To:	DA Mattox
From:	Thomas Melville
Date:	March 27, 2018
Subject:	SAFEbuilt Permit Review – Design Team Comment Response

The purpose of the memorandum is to capture and provide response to SAFEbuilt Permit Drawing Review Comments for East Tower Expansion as received on March 23, 2018. Drawings are in the processes of being revised and are to be issued as Addendum No. 2 to direct the CM for revisions. Subsequent to this issuance, a full permit set will be issued to SAFEbuilt.

MMC EAST TOWER – BUILDING REVIEW

2 CURTAINWALL - SCUPPER
1 1/2" = 1'-0"

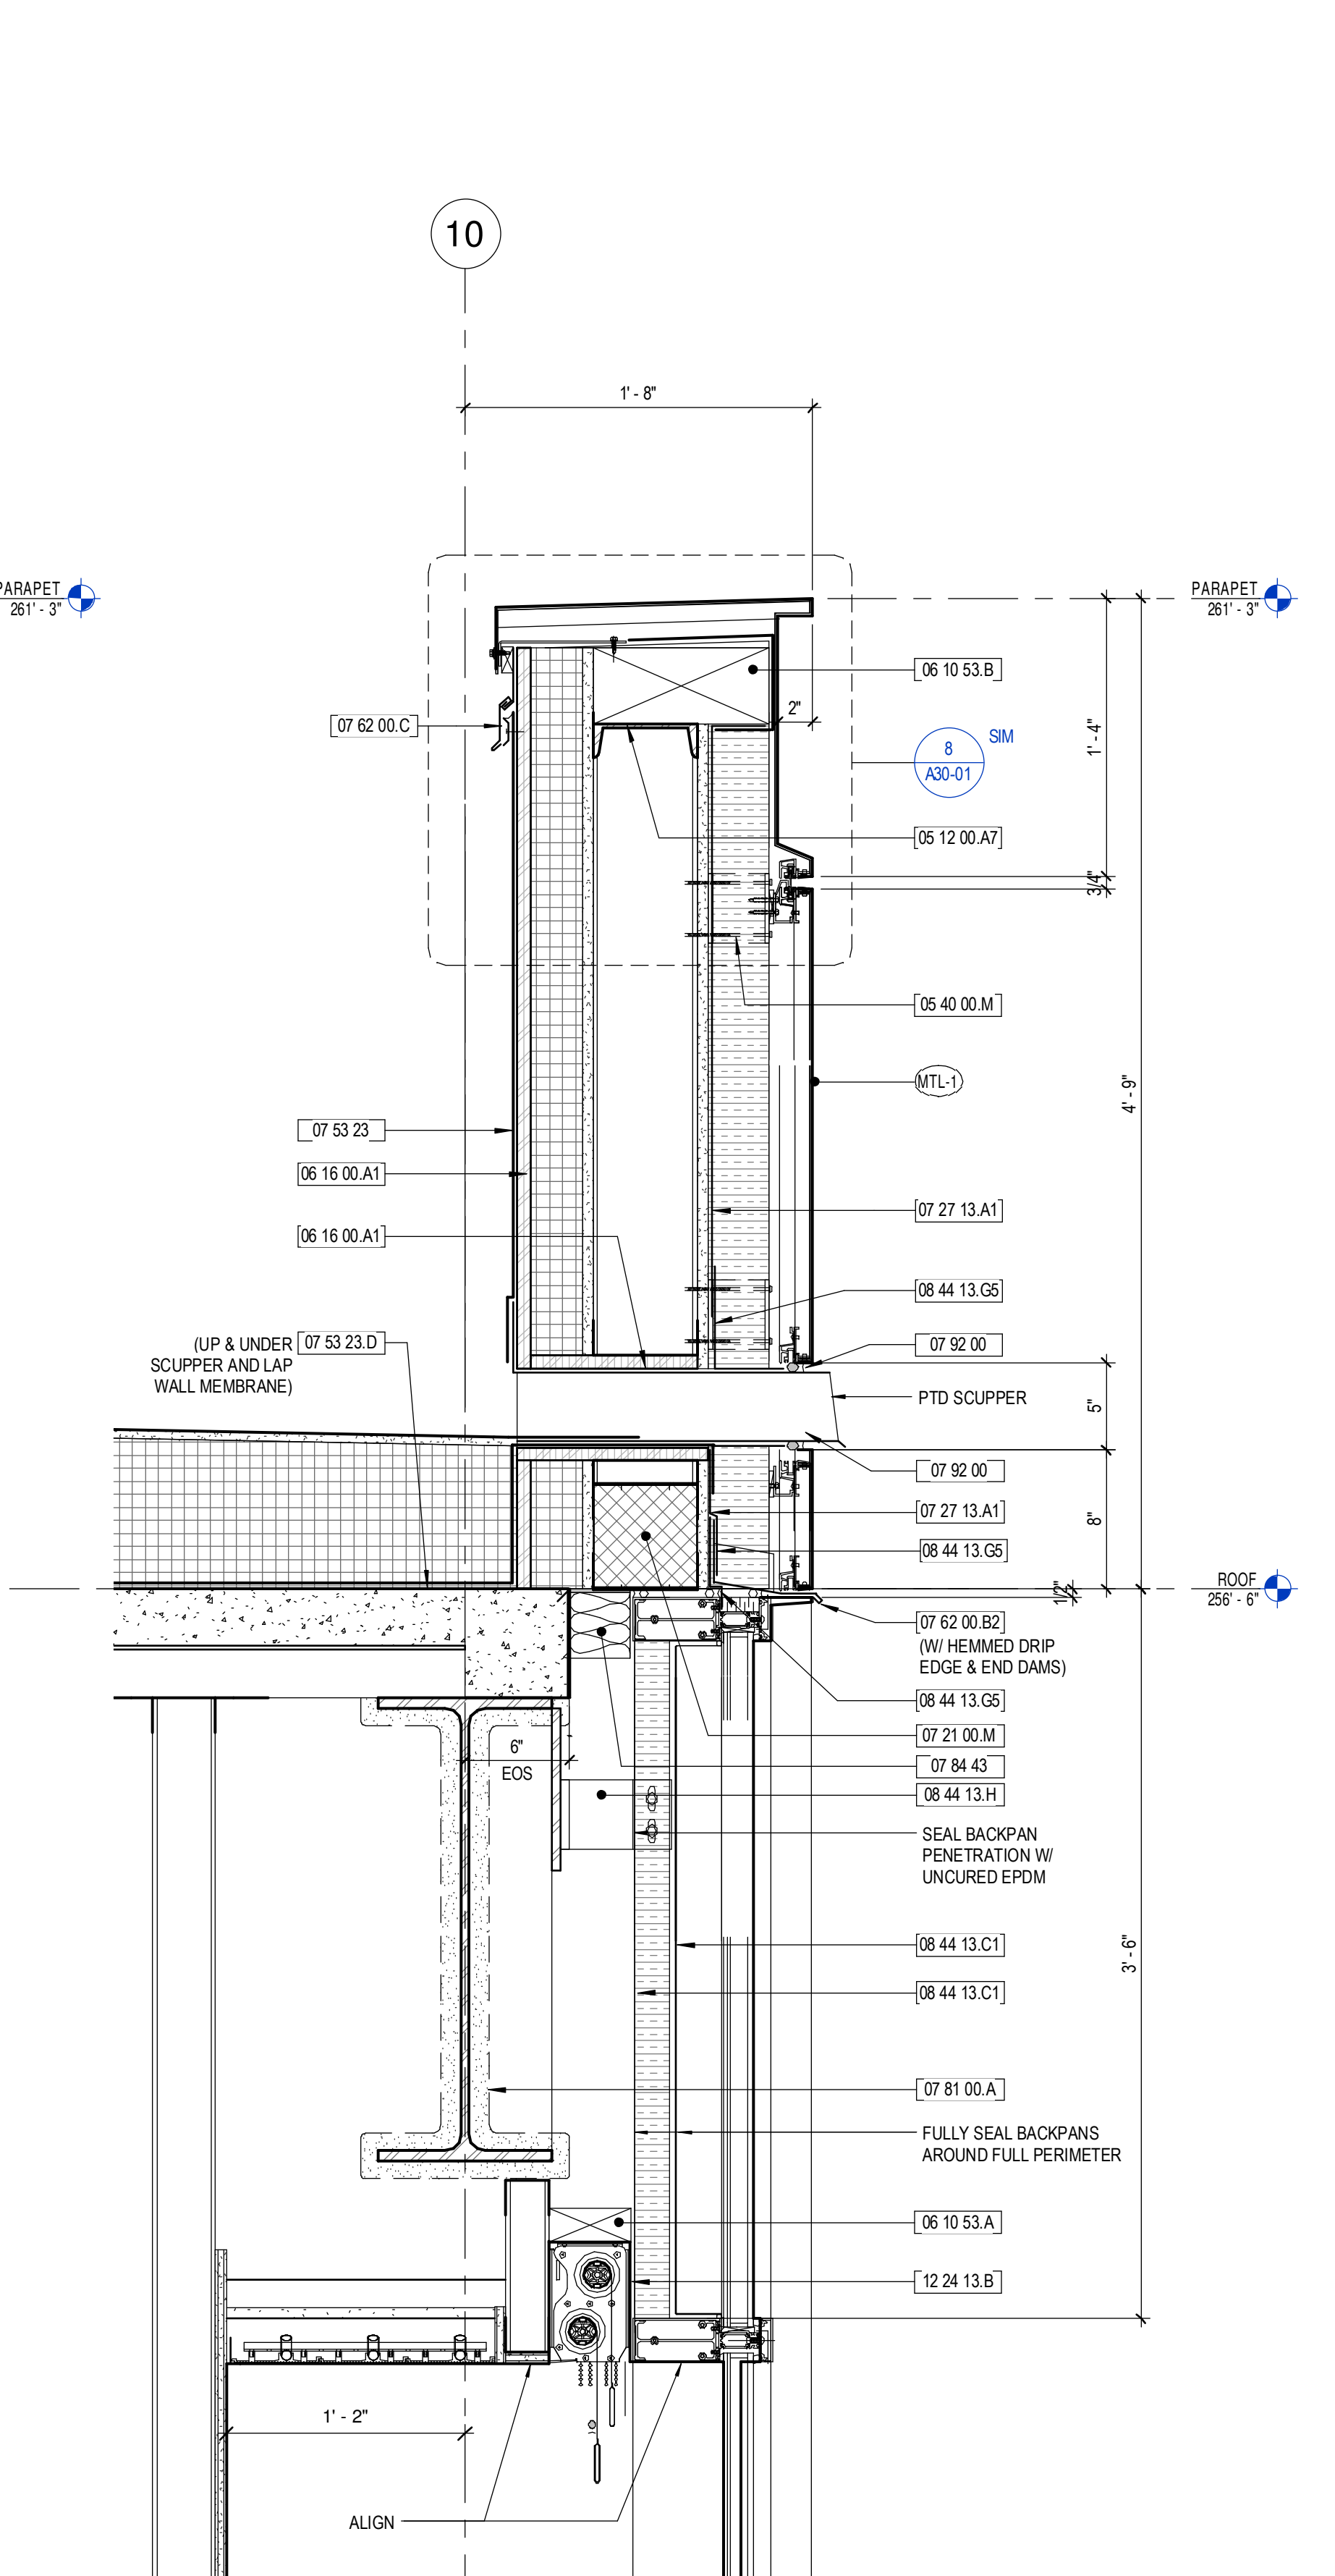
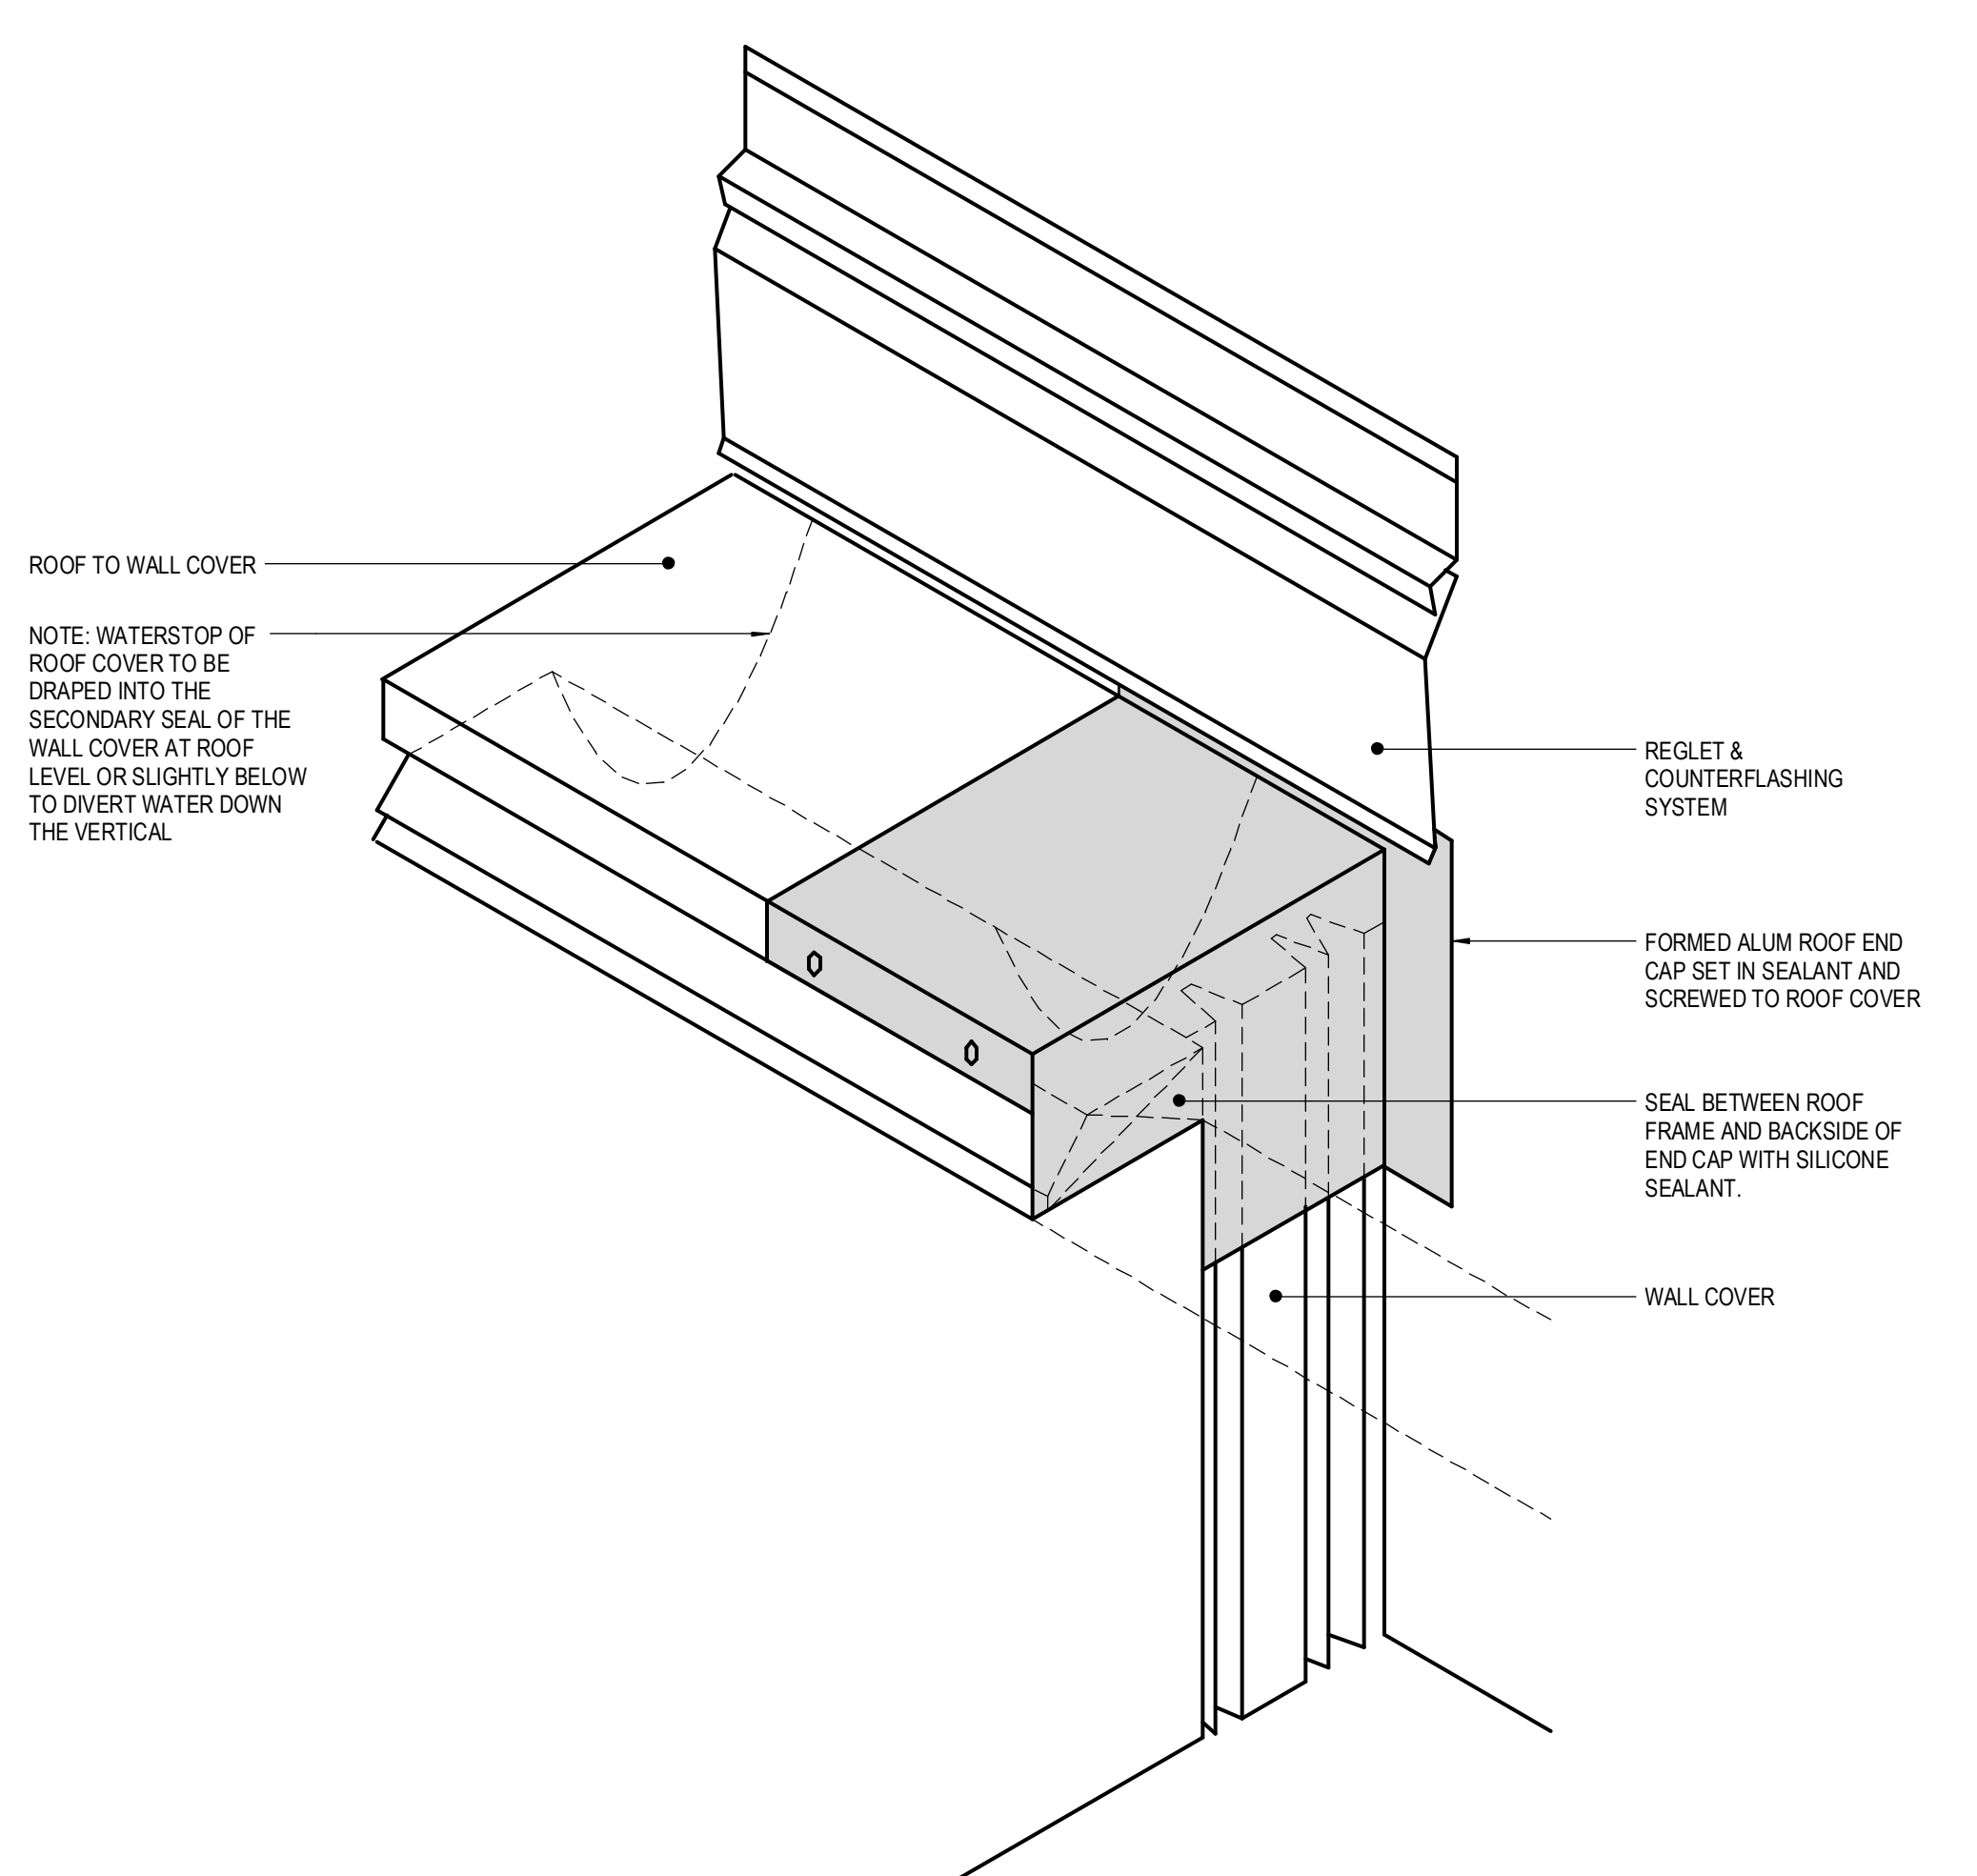
Provide the required fire-resistance ratings for the primary structural frame. A project code summary / analysis is not provided and the various details that show protected primary steel members (exterior section details on sheet A32-01 for example) note the protective material but do not provide a thickness or hour rating.

Exterior section details (sheet A32-04, etc.) specify pressure-treated wood blocking which is not included on the list of permitted combustible materials in Type 1 construction per IBC 603.1.

Fire resistive ratings for primary structural frame provided in Code Report distributed 3/16/2018.

Pressure-treated blocking will be replaced with fire-retardant-treated blocking. This revision will be indicated in Addendum No.2. IBC 603.1 allows fire-retardant-treated wood in non-bearing exterior wall where fire-resistance-rated construction is not required. Refer to Table 602 discussion in Code Report.
